REQUEST

Current Zoning: N1-D (neighborhood 1-D), N2-B (neighborhood 2-B), and B-1(CD) (neighborhood business, conditional).
 Proposed Zoning: N2-A(CD) (neighborhood 2-A, conditional)

The petition proposes the development of up to 29 multi-family attached dwelling units. The site is currently developed with a commercial building and a material storage yard.

Chris Foley, Alchemy Development, LLC

# RZ.01

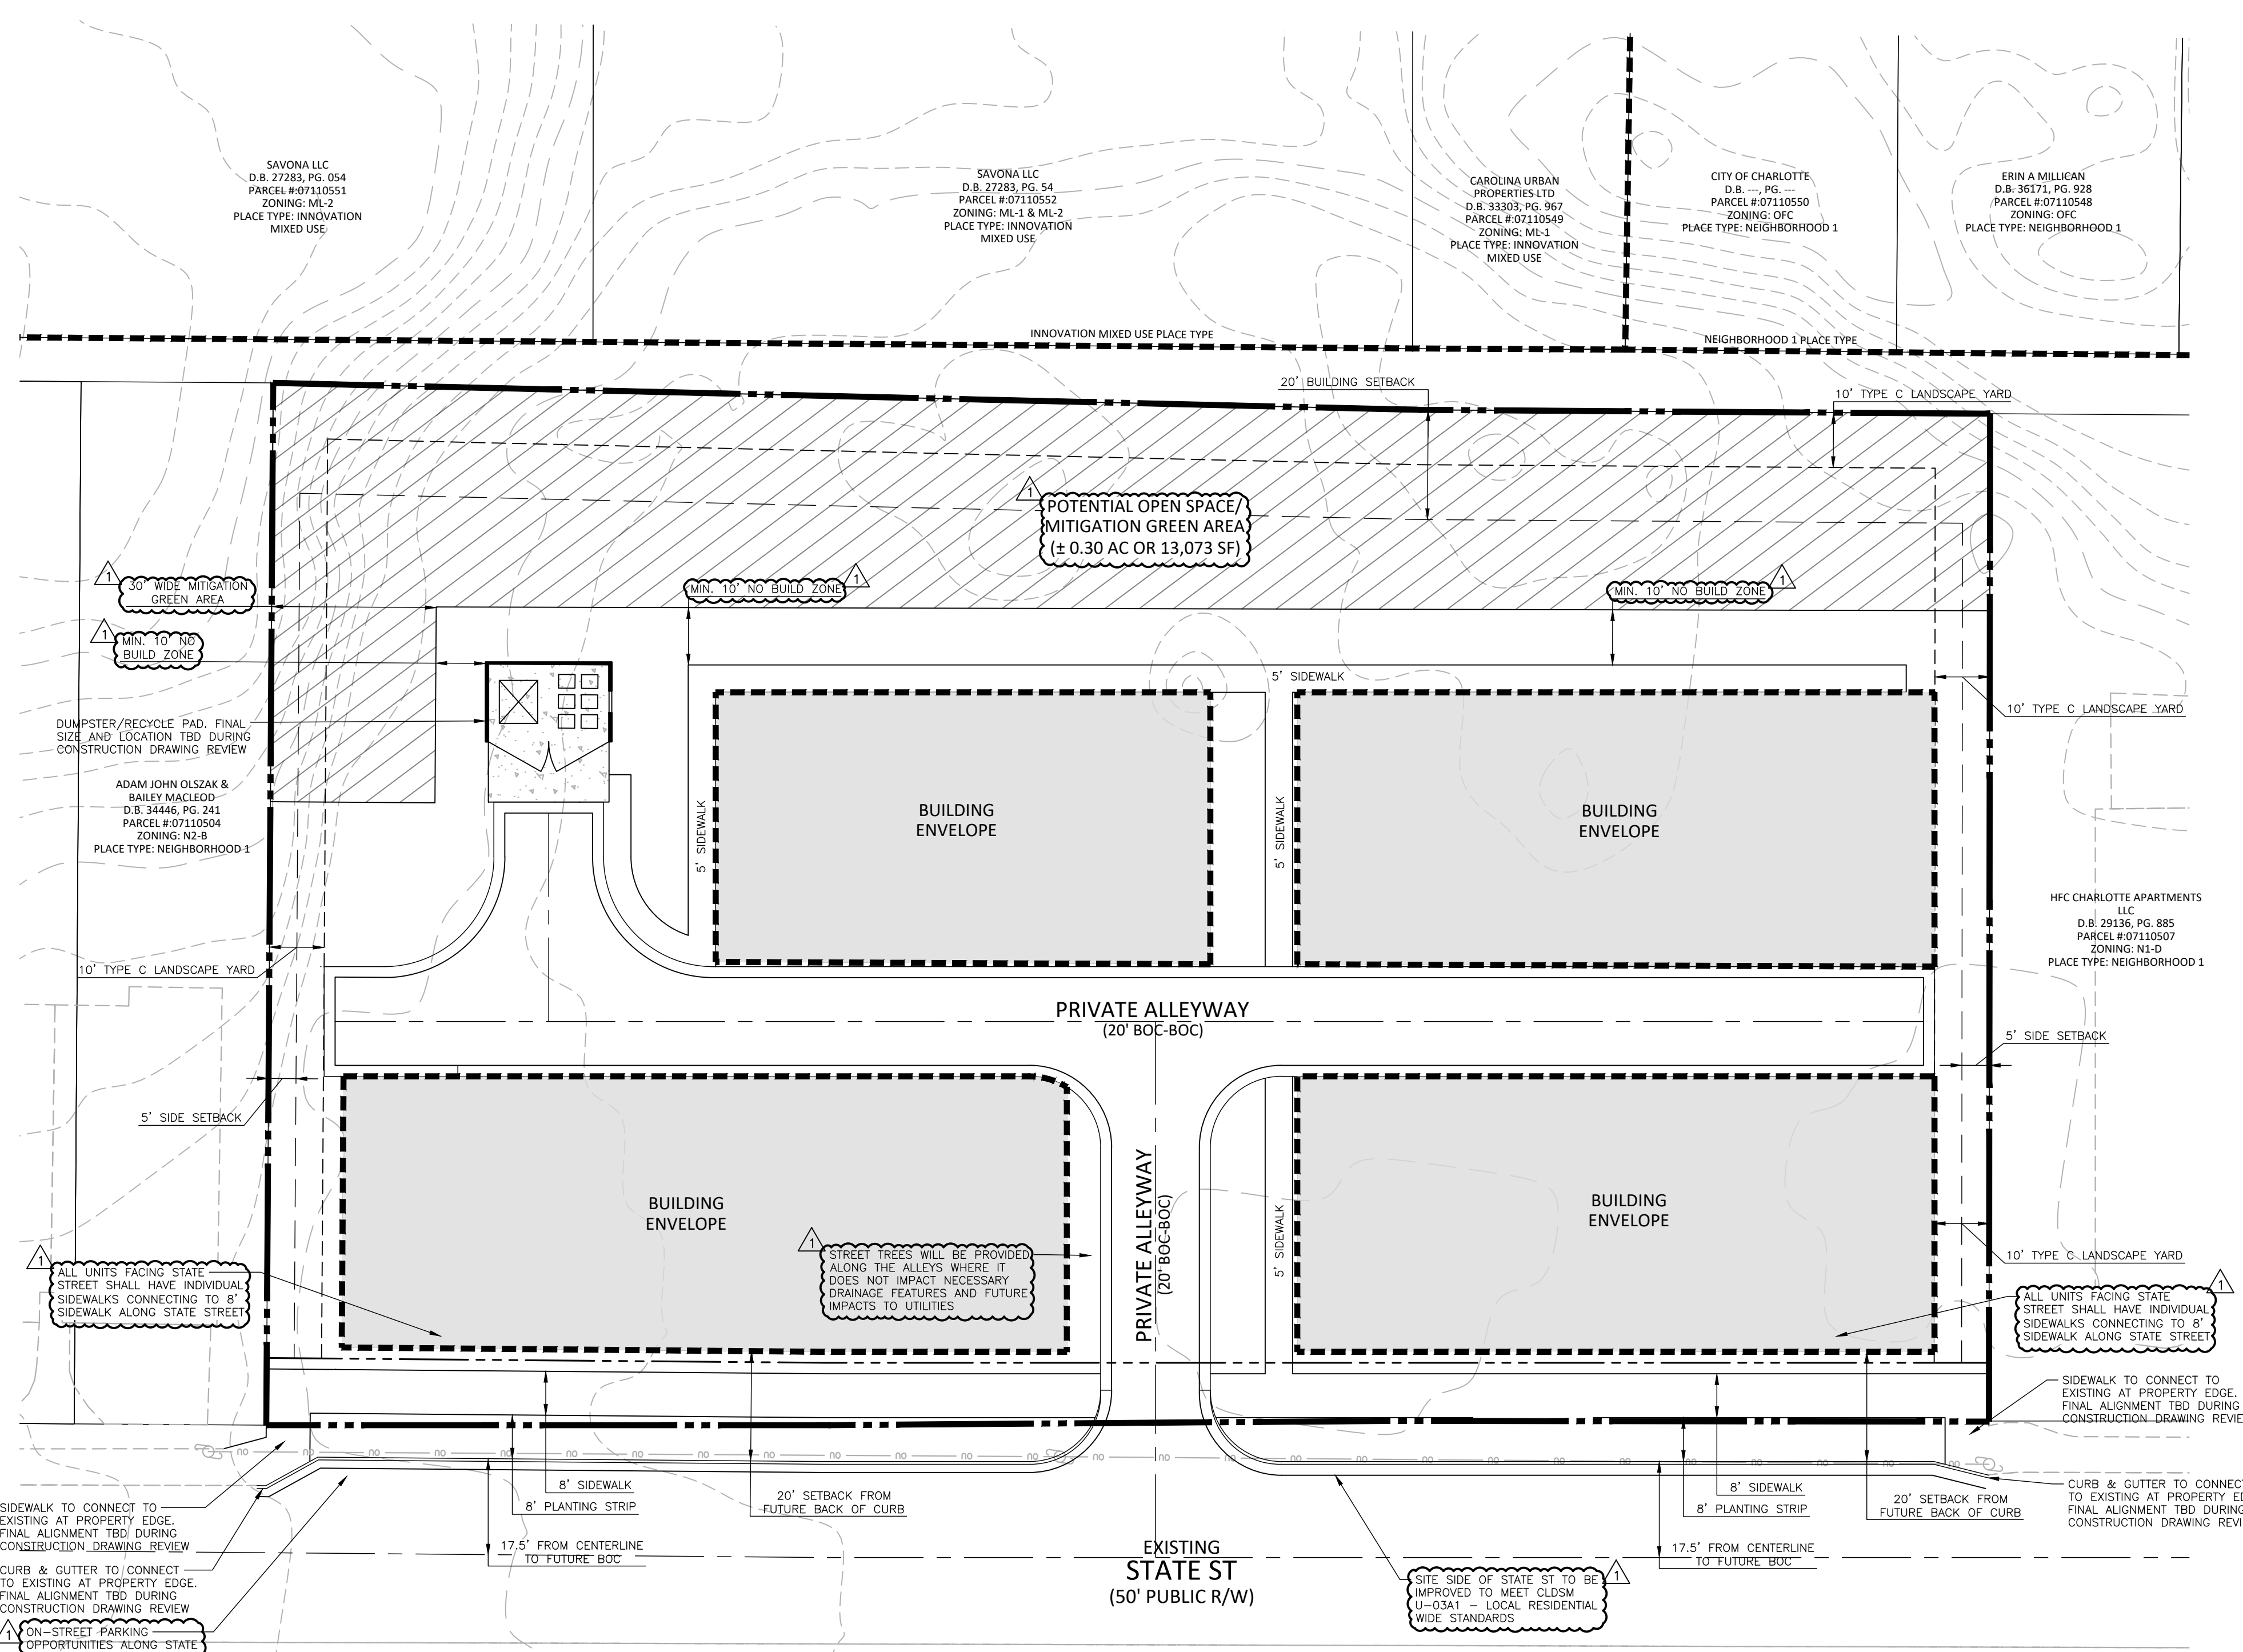
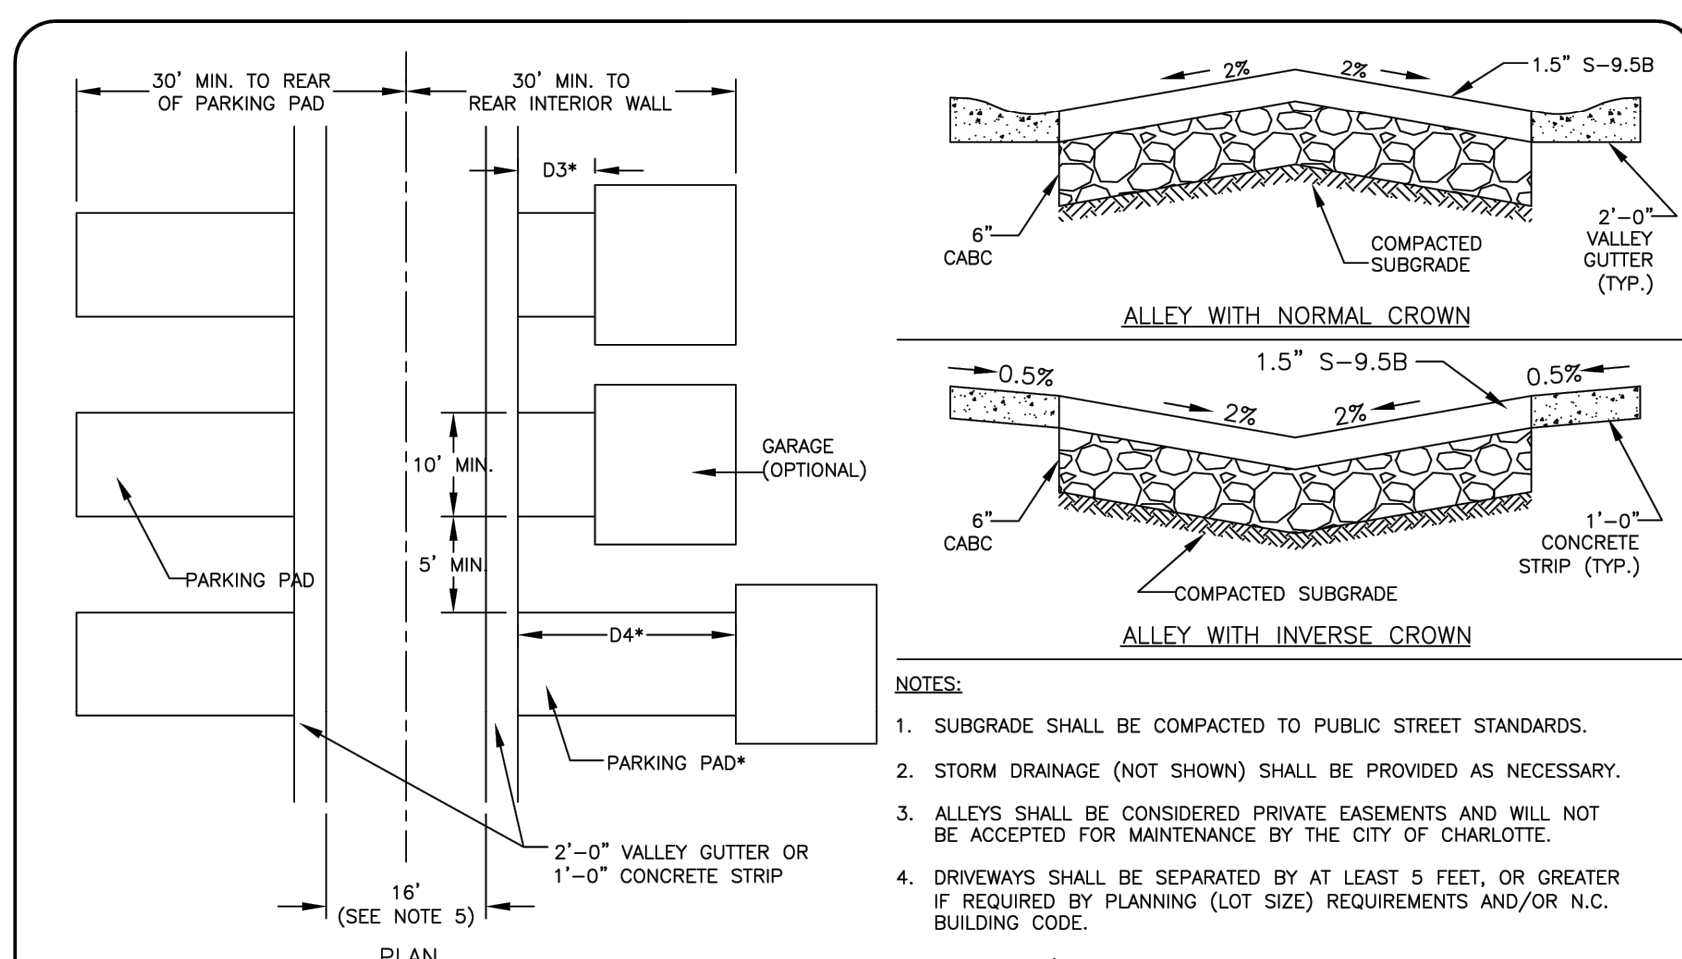
1. Entitlement Services: ~~specify a minimum number and maximum spacing for proposed alley street trees.~~ **Addressed**
